ROLLIN RIDGE Filing No. 1 Construction Drawings El Paso County, Colorado

ROLLIN RIDGE - FILING NO. 1

Construction Drawings_V1.pdf Markup Summary

Pavement Marking and Sign Plan for Construction
Rollin' Ridge Filing 1
Cherry Crossing Drive (Part 1 of 2)

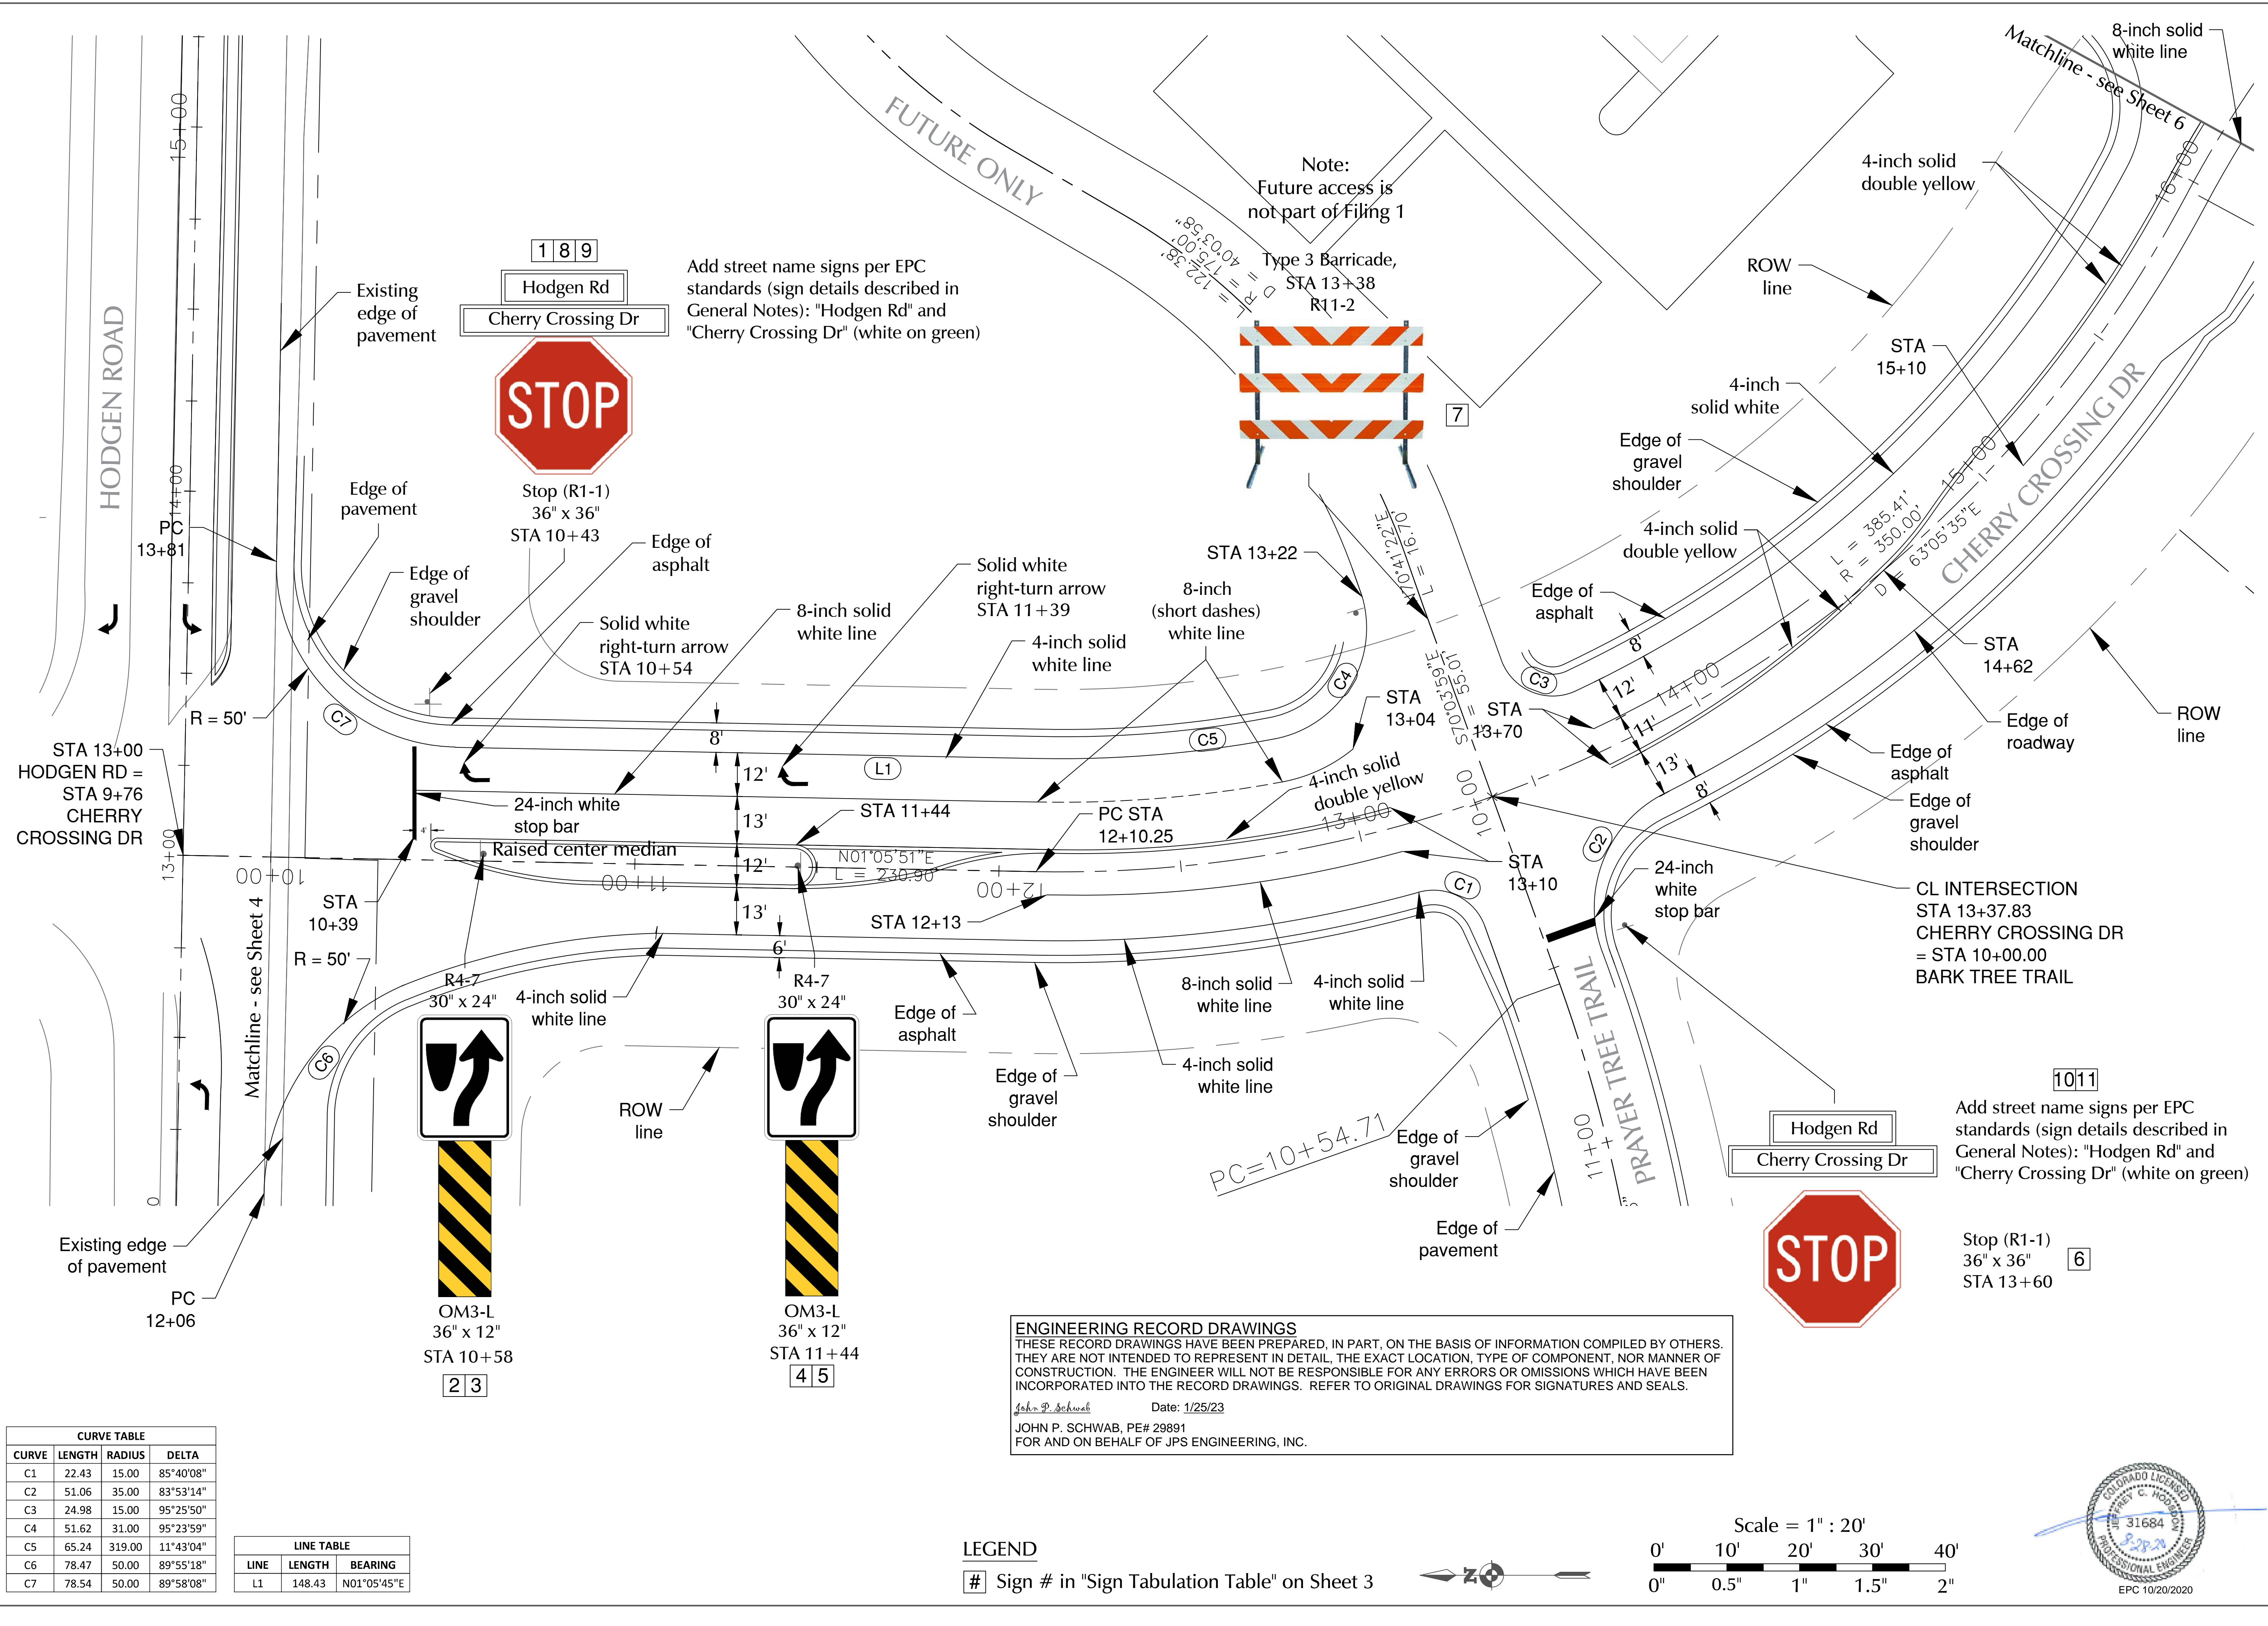
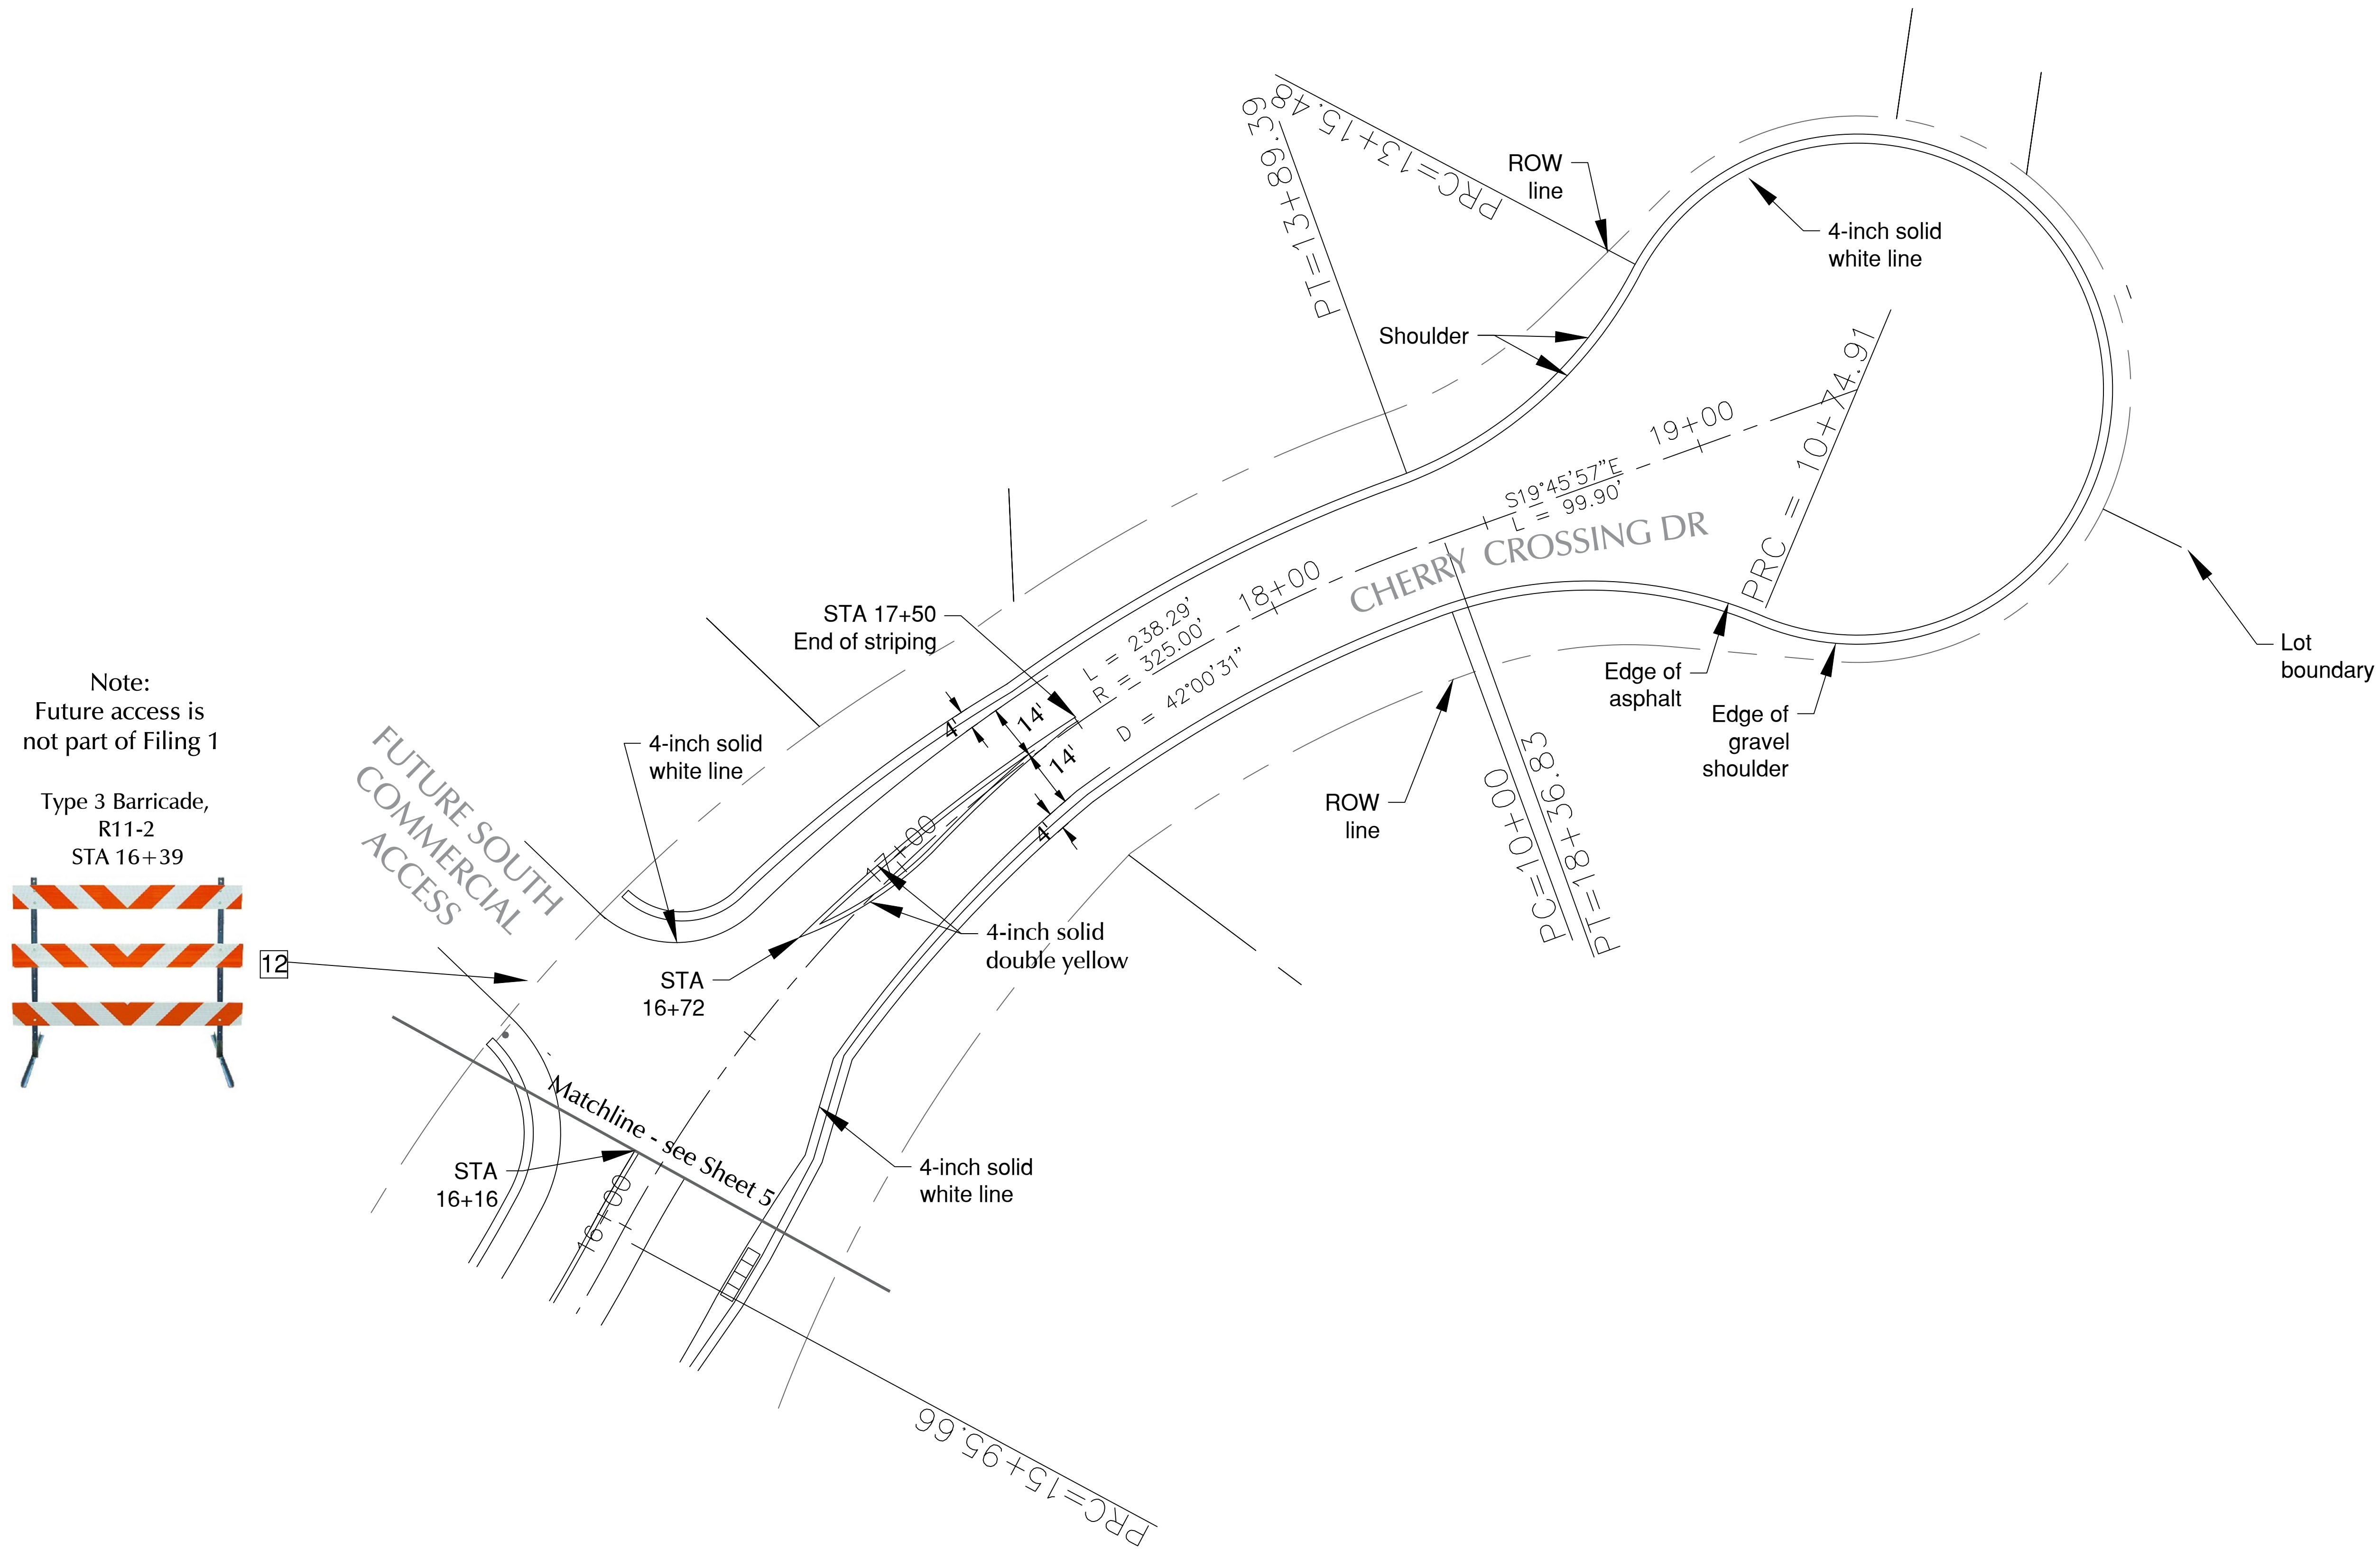
Provide a signage and striping plan.

Review the Traffic Impact Study recommendation. It notes restriping on Hodgen Road is required.
